MECKLENBURG COUNTY
Park and Recreation Department

MEMORANDUM

RE: Rezoning Petition #2023-013
PID# 21917287

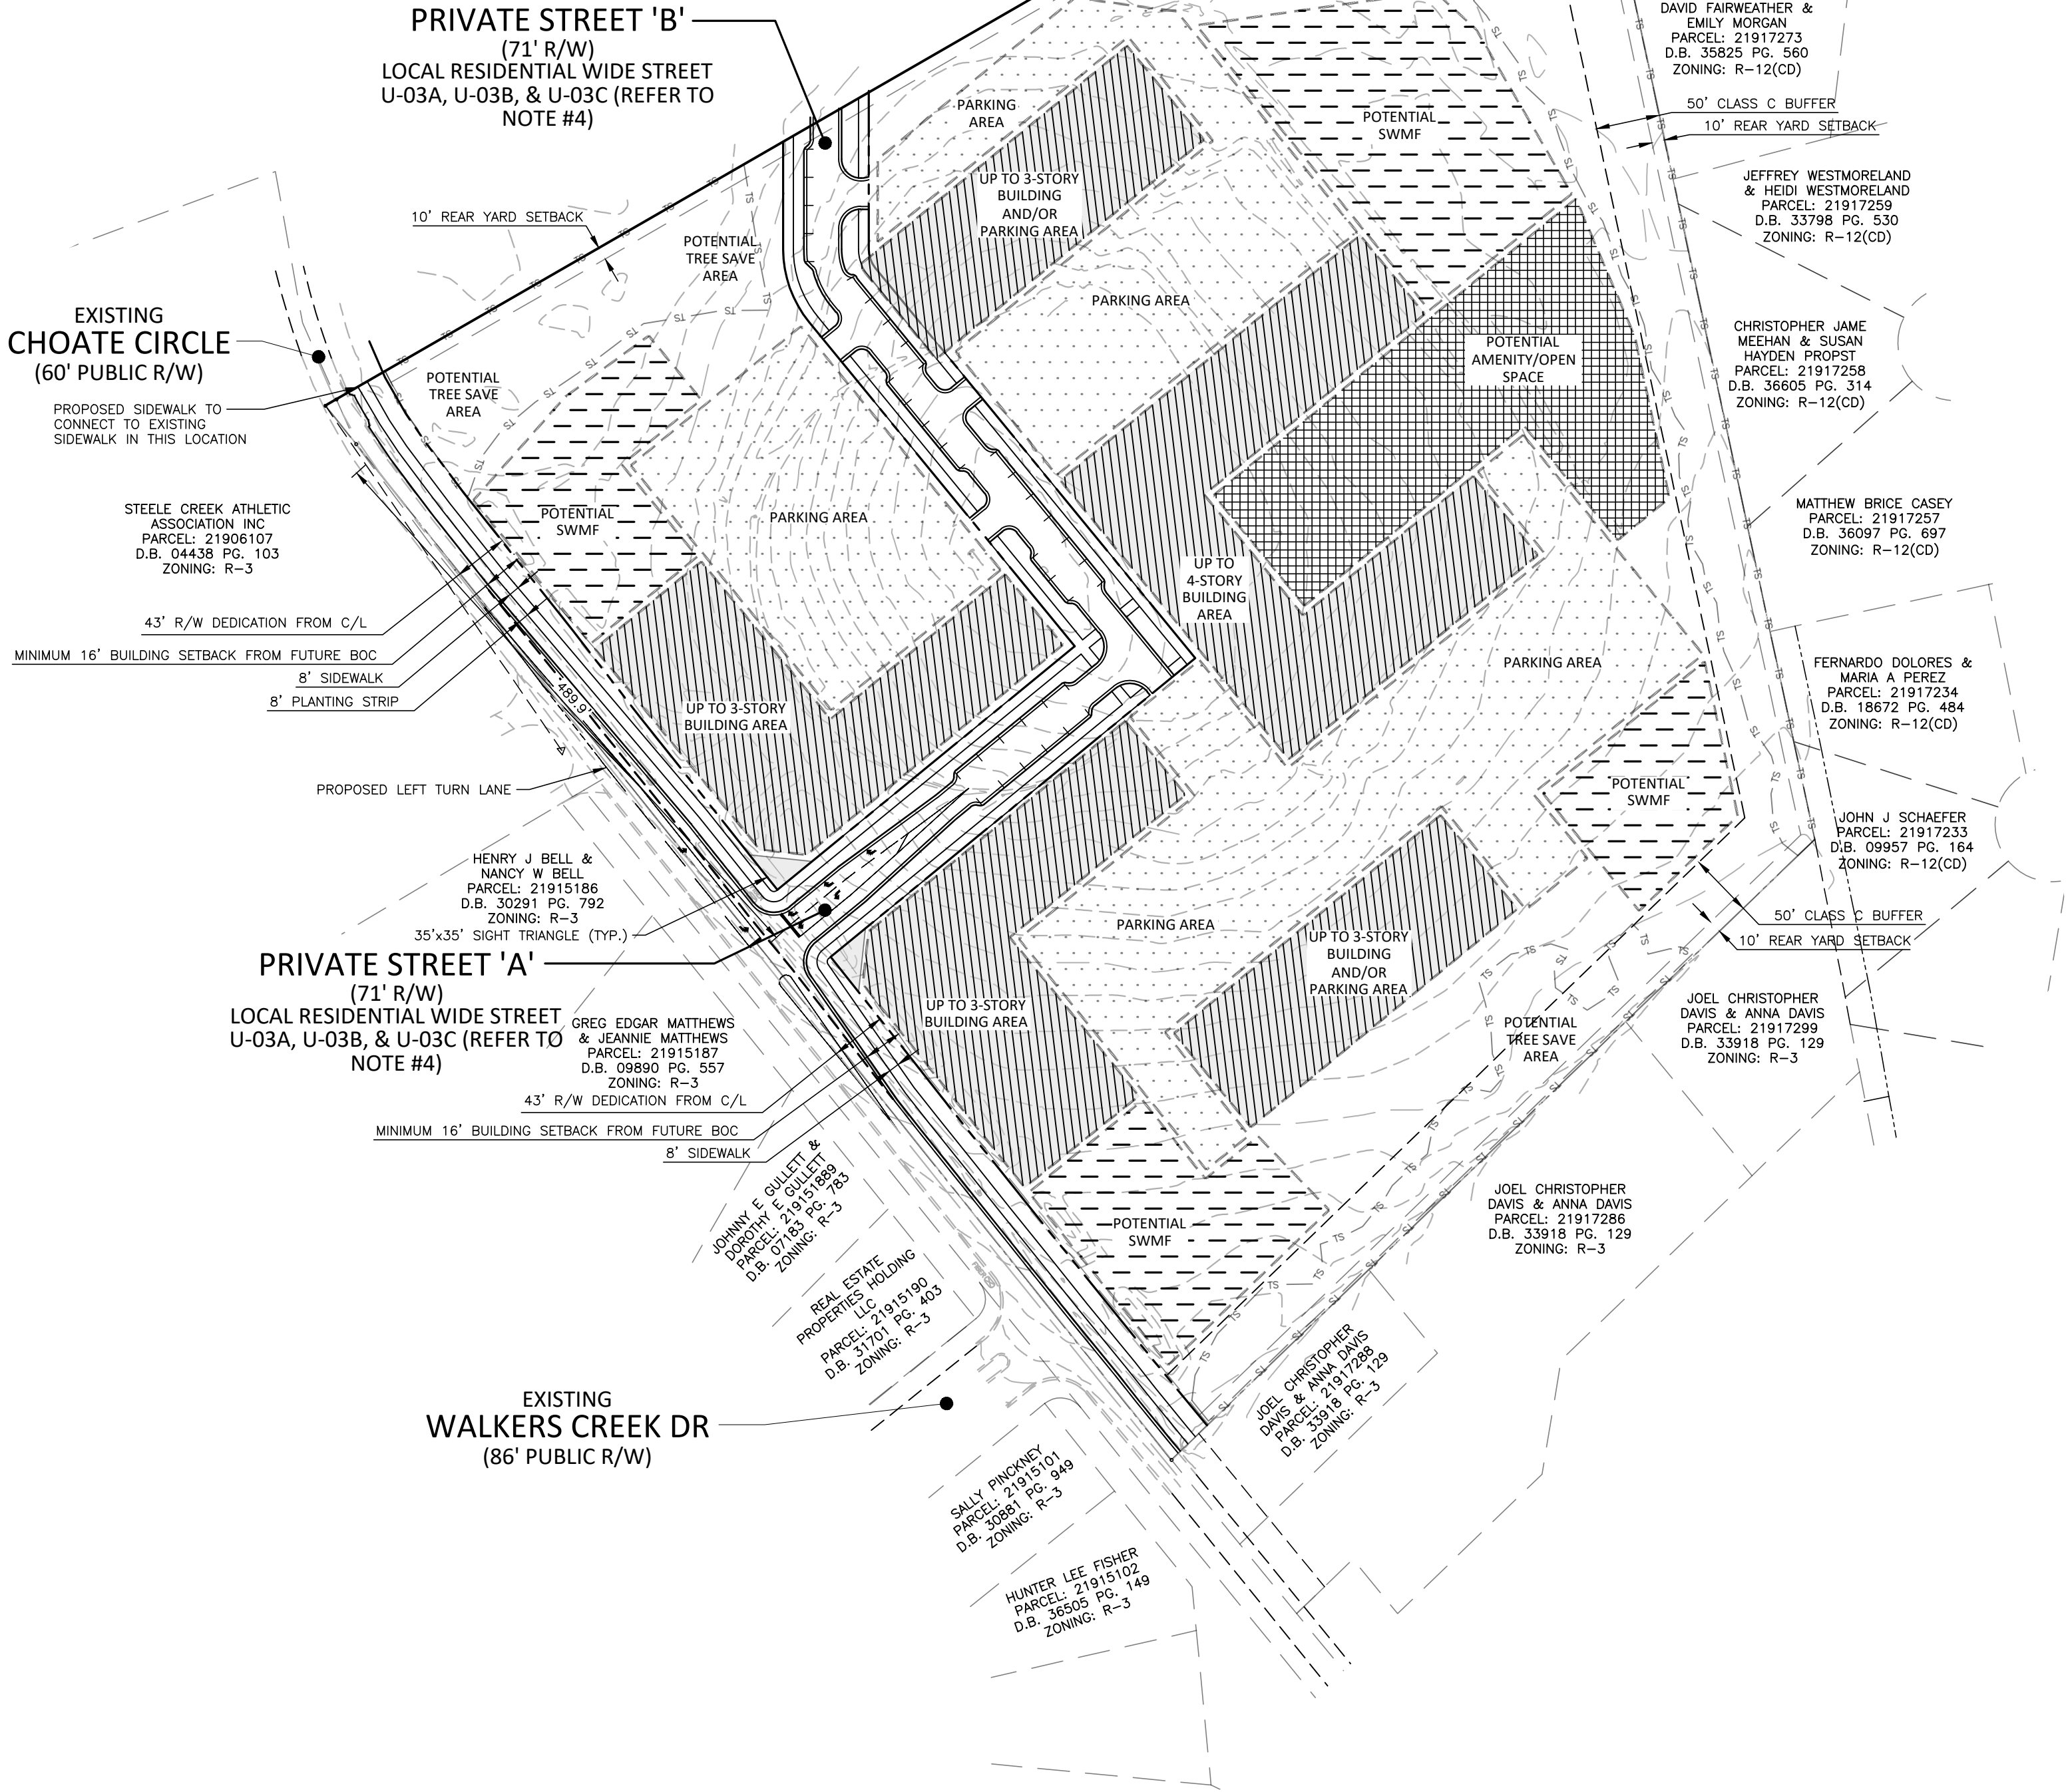
MCPR requests a minimum of **1.0** acre to be dedicated and conveyed to Mecklenburg County for a future neighborhood park. This requested park land shall be adjacent to a public right-of-way for access and is conducive for the development of the typical amenities found in a neighborhood park and cannot include tree save parcels or stormwater BMP's.
